From: Paul Cann <Paul.Cann@arun.gov.uk>
Sent: 09 October 2020 11:18
To: Planning.Responses <Planning.Responses@arun.gov.uk>
Subject: RE: Planning Consultation on: P/86/20/PL

Application No: P/86/20/PL
Registered: 26th August 2020
Site Address: Bowley Farm Bowley Lane South Mundham Chichester PO21 1NB
Grid Reference: 489226 98589
Description of Works: Retention of 4 No. mobile homes for countryside workers together with drainage & service connection provision in connection with permission P/72/09 as varied by P/22/017/PL. This application is in CIL Zone 5 (Zero Rated) as 'other development'.

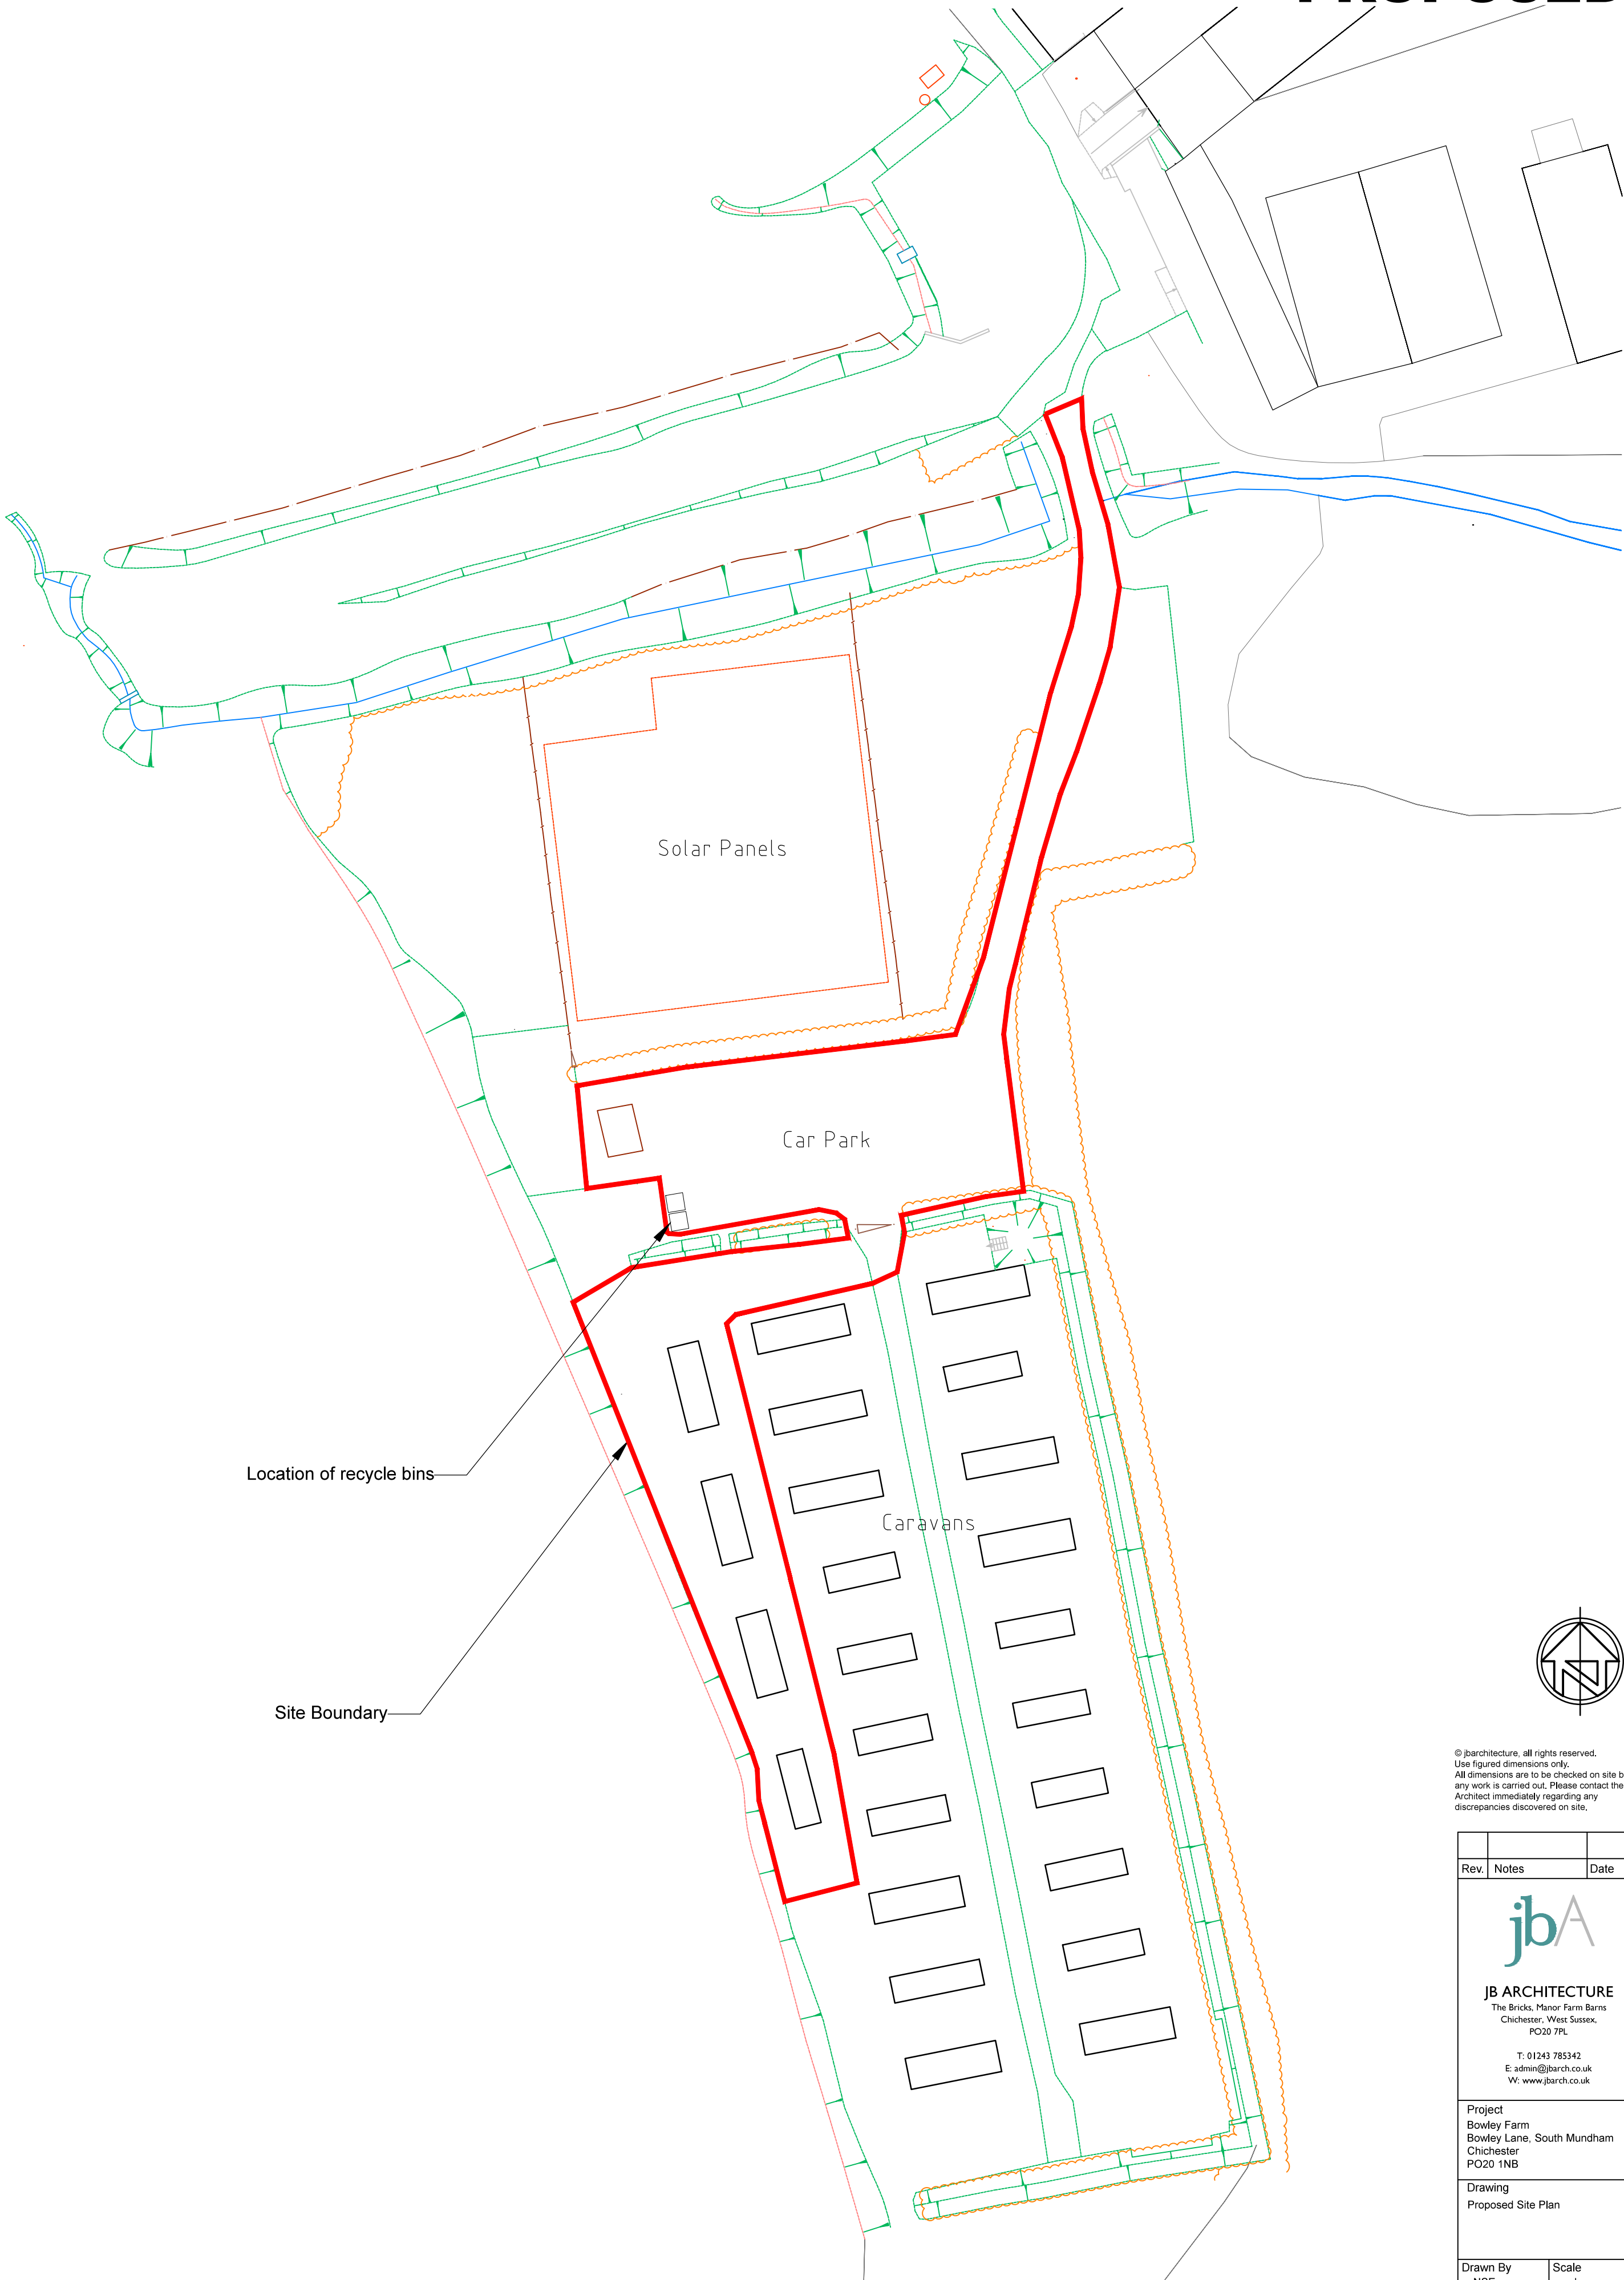
The proposed mobile homes are not within the current flood zone as detailed on the Environment Agency mapping. Neither are they within the future predicted flood zone (up to year 2111).

However, the access road is partly within the current/future flood zones and therefore the applicant should note that restricted access to the site may be a possibility on occasions.
